Application No: FG/46/21/PL
Site Address: Land between 11a The Grove and 30 Brook Lane Ferring
Description of works: Development of 1 no. 2 bed house set over 2 floors, with first floor being partially contained within roof, along with associated parking & amenity spaces. This site is within CIL Zone 4 and is CIL liable as new dwelling.

Thank you for your internet representation made on 20th April 2021 which has been recorded as an objection with the comments as follows:

Planning Reference FG/46/21/PL Land between 11a The Grove and 30 Brook Lane Ferring

Drawing Title 028_07 Proposed West & South Elevations Land between 11A The Grove and 30 Brook Lane, Ferring	
Completion date 17/03/2021	
Drawn by Guy Rochez	
Scale: 1:100@A3	
Print Size: A3	
Notes:

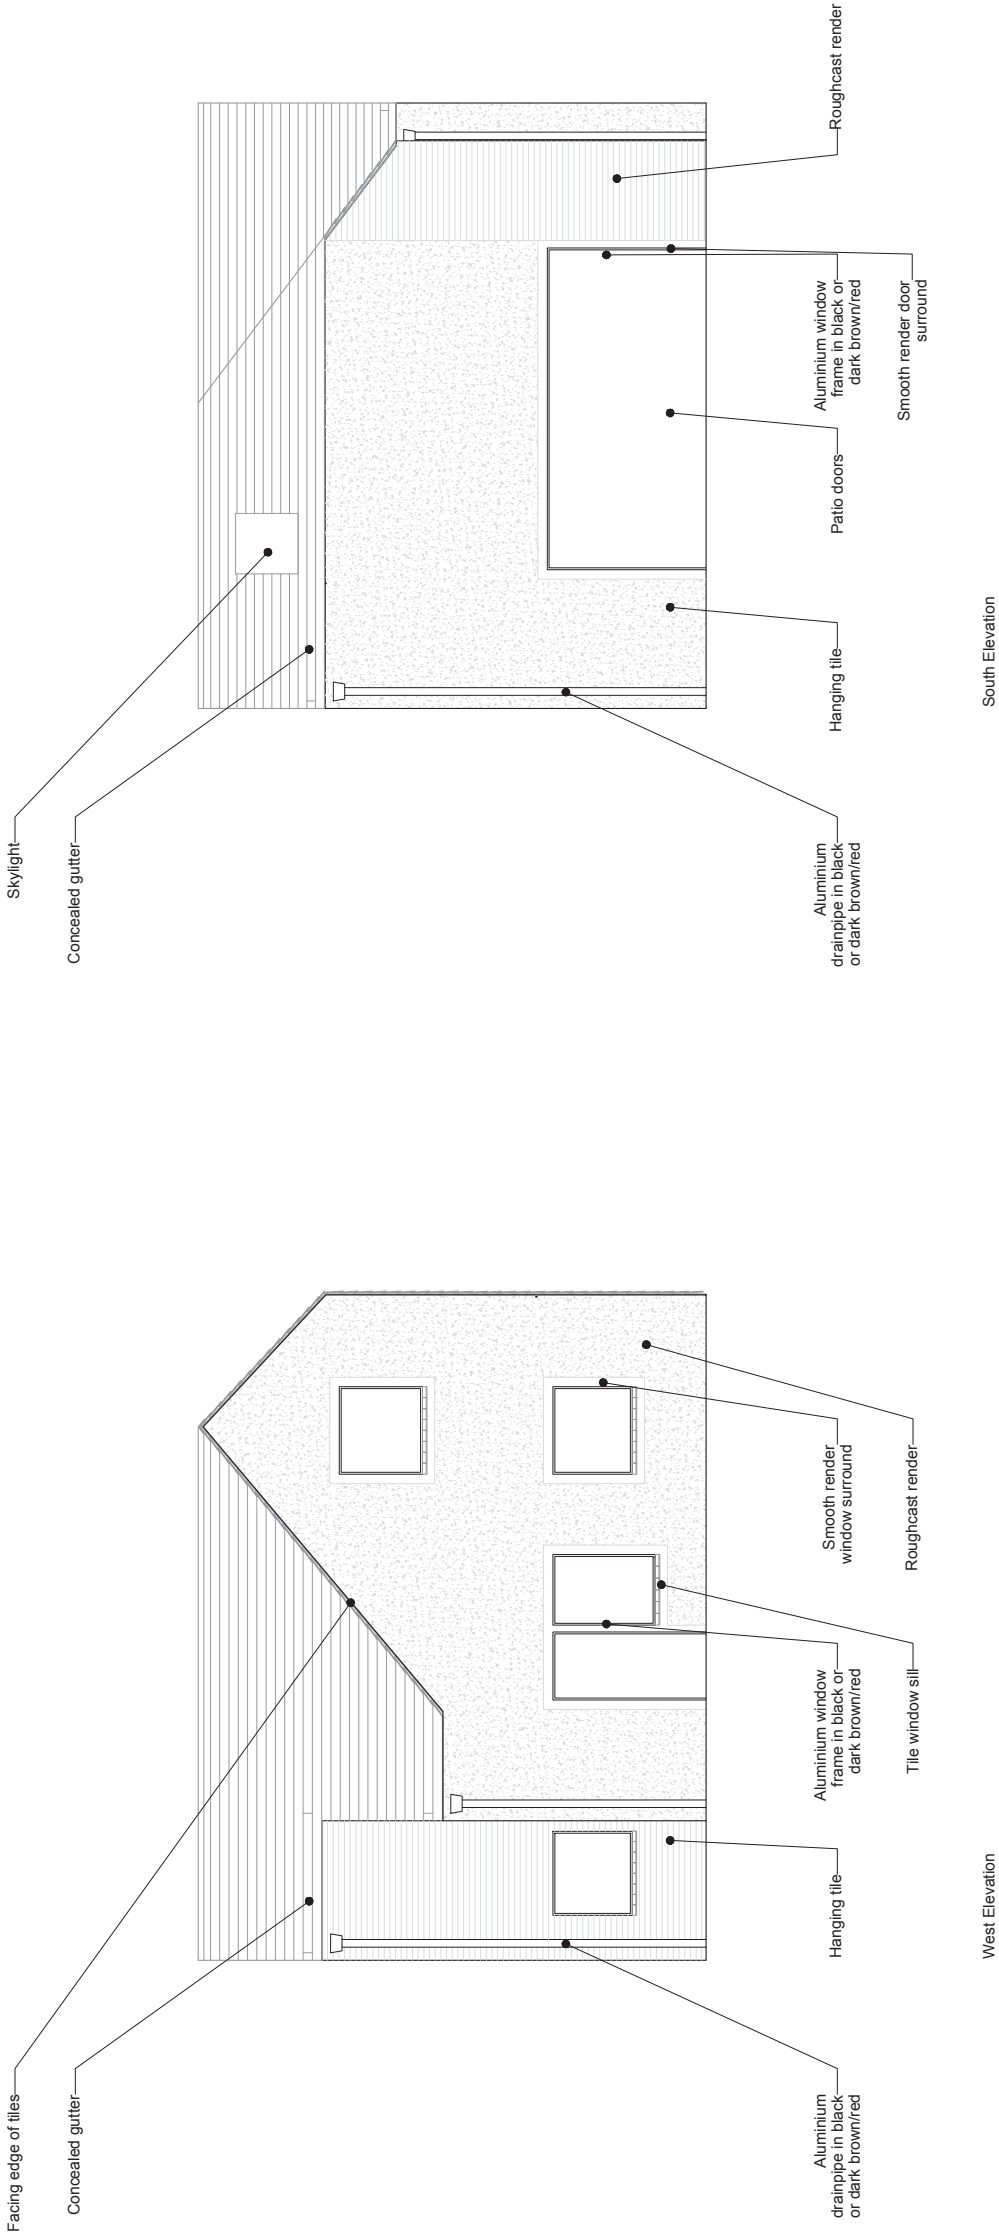
The proposed development by reason of its size, depth, width, height and the position on a plot too small for purpose will have an unacceptably adverse impact on our home life and the continued use and enjoyment of our garden and home. Such close proximity of the entire width of the rear elevation of this two-storey property which has been shoehorned right back along the west boundary of our garden will be claustrophobic, overbearing and intrusive.

- It fails to provide the recommended 10.5 m depth for new build gardens
- It fails to provide 21m separation between habitable rooms
- It fails "to have minimal impact to users and occupiers of nearby property. For example by avoiding significant loss of sunlight, privacy and outlook"

Drawing Title 028_02 Proposed Ground Floor Plan Land between 11A The Grove and 30 Brook Lane, Ferring					
Completion date 17/03/2021					
Drawn by Guy Rochez ARB					
Scale: 1:100@A3					
Print Size: A3					
Notes:

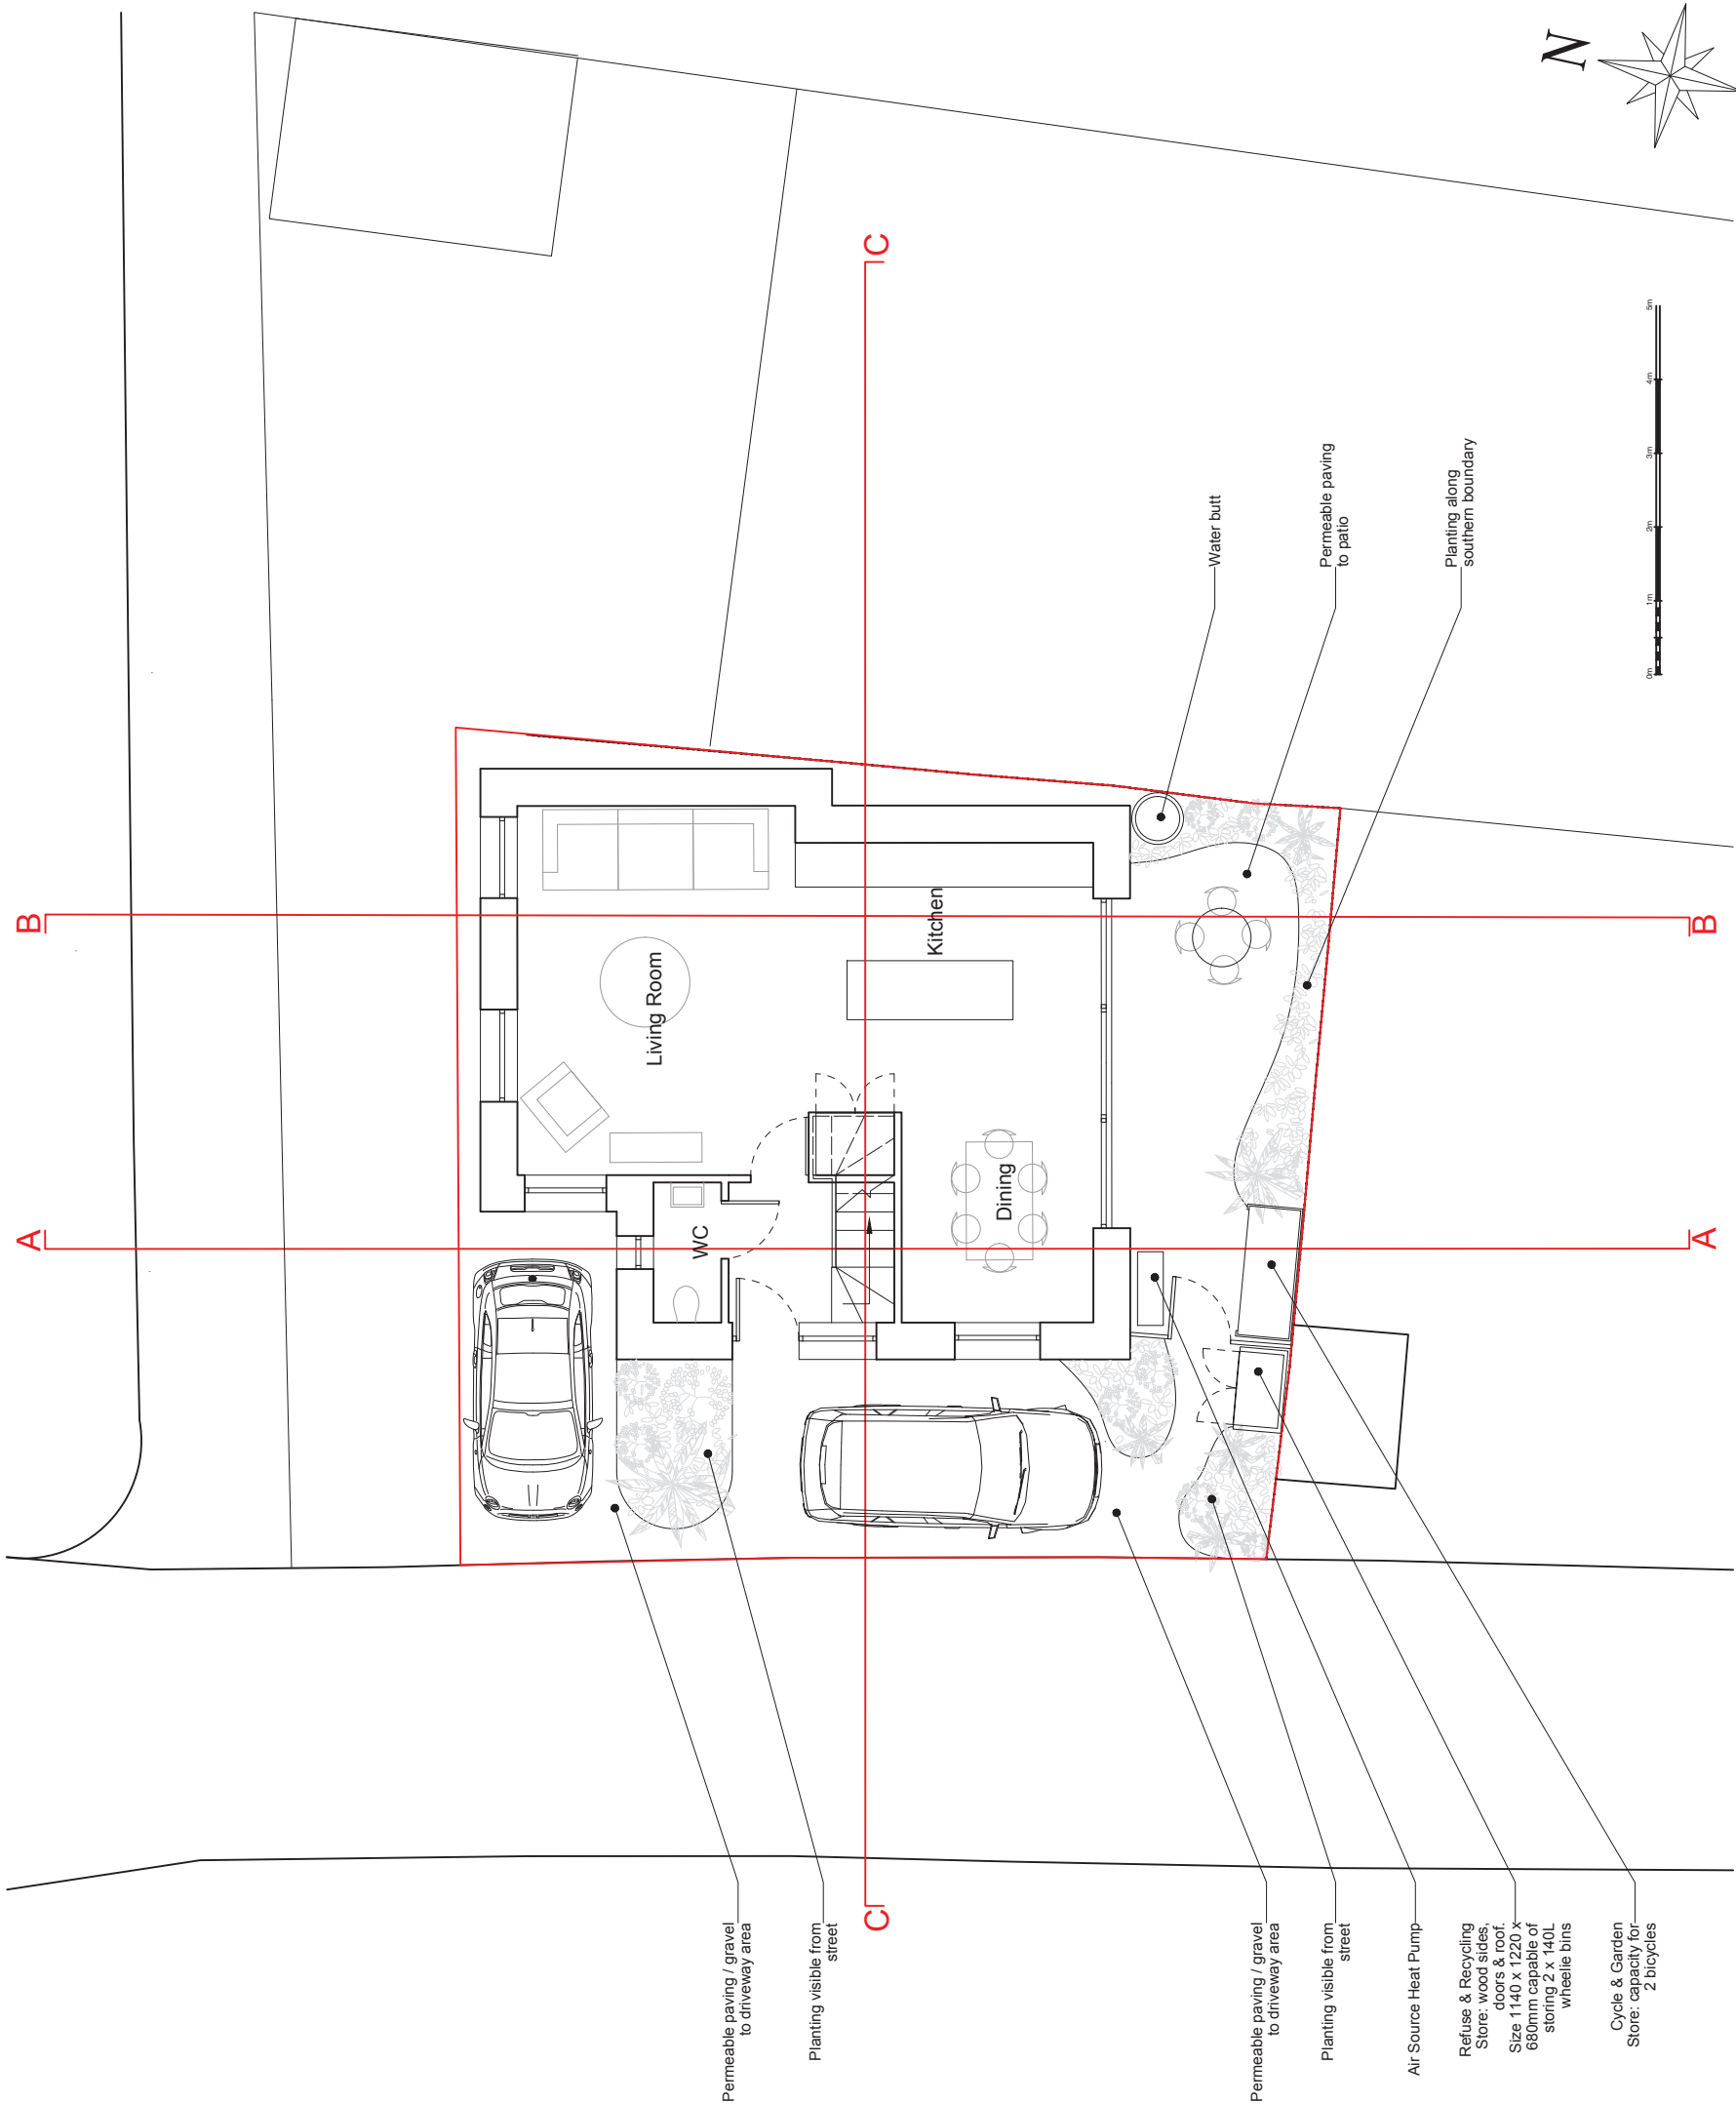
This proposal fails to meet West Sussex County Council's Highways Authority standards and I quote from their consultation document "one of the spaces does not meet the minimum specification". An average-size vehicle will protrude into the road causing a line of sight hazard when exiting the drive to 24 Brook Lane's rear parking, and will be a hazard to traffic and pedestrians. West Sussex County Council Highways Authority have also expressed concern "The LPA may wish to consider the amenity impact of the proposed smaller space and whether this would impact upon on-street parking in this location"

The ground floor windows to the north elevation open out and intrude into the 8ft wide access road to our rear parking, rendering it unusable if the windows are opened. If the windows open inwards, the available internal living space will be reduced accordingly.
